**Case Officer:** Emma Whitley**Recommendation:** Refuse**Applicant:** Robert Hooke**Proposal:** Certificate of Lawfulness of Proposed Development to replace the flat roof on garage with pitched roof with tiles to match house**Expiry Date:** 31 August 2021

8 Rectory Close, Wendlebury, OX25 2PG

Drawing Title
PROPOSED ELEVATIONS

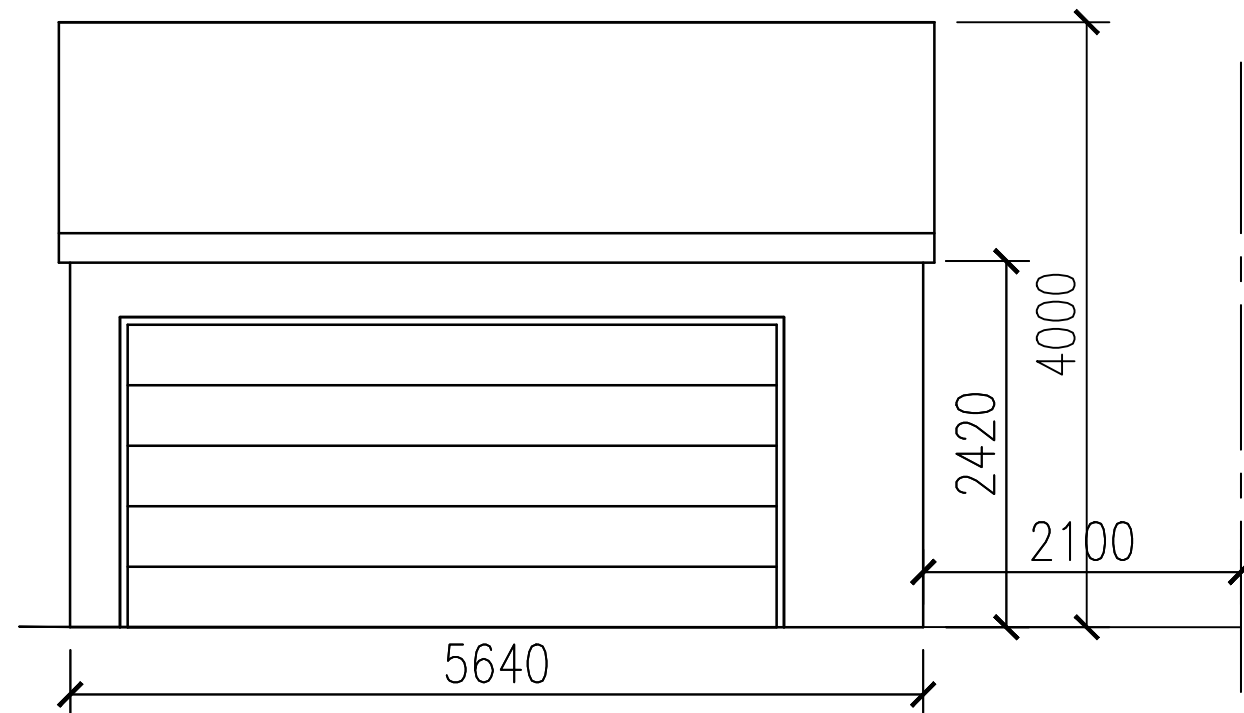
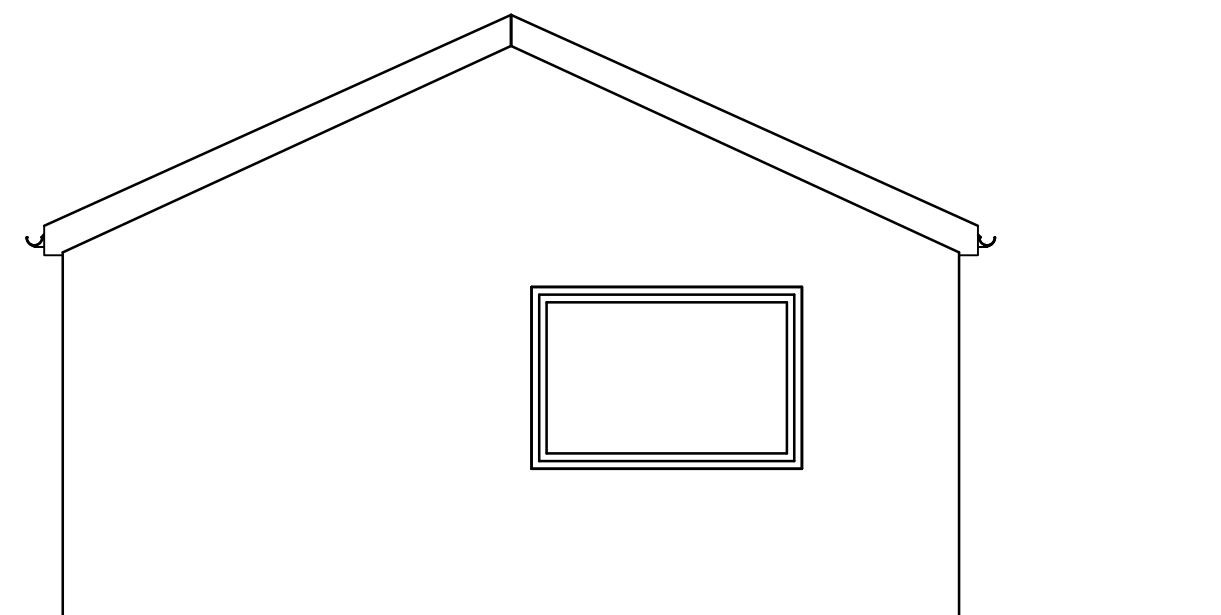
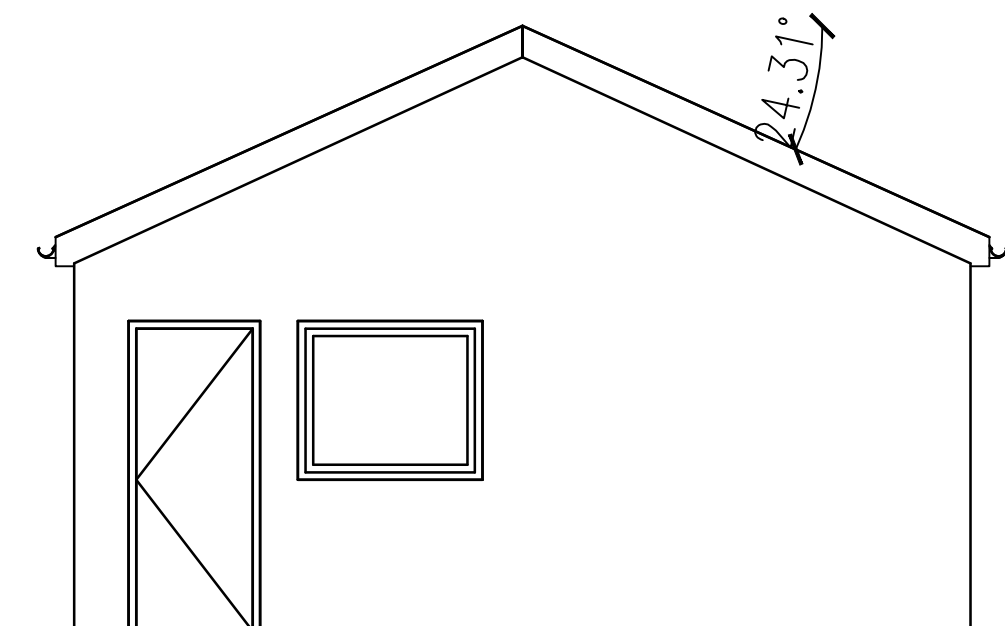
8.7. The height of the eaves would exceed 2.5m: the eaves height would measure 2.6m;

The eaves of the altered outbuilding would exceed 2.5 metres in height and therefore the proposal would not constitute permitted development under Schedule 2, Part 1, Class E of the Town and Country Planning (General Permitted Development) (England) Order 2015 (as amended).

Drawing Title
PROPOSED GROUND FLOOR GA PLAN

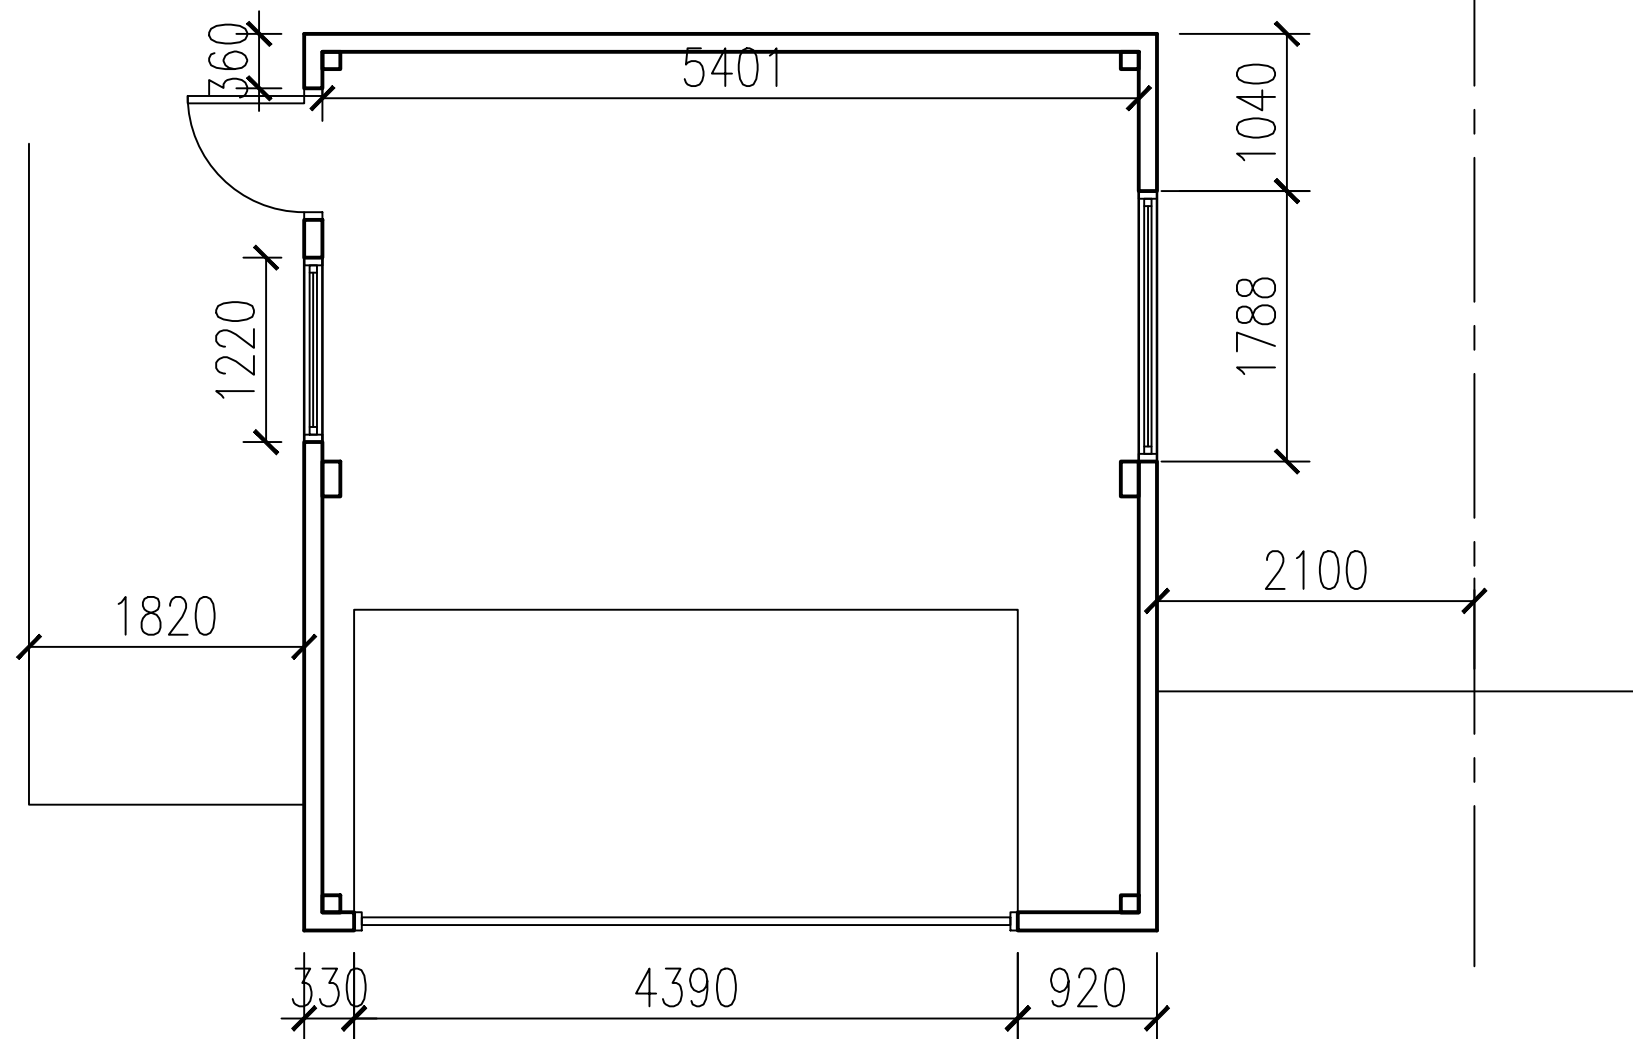
8.4. The plans are not clear as to whether the garage is set behind the front elevation of the dwelling but it appears from a site visit that the proposed garage is not situated on land forward of a wall forming the principal elevation of the original dwellinghouse;
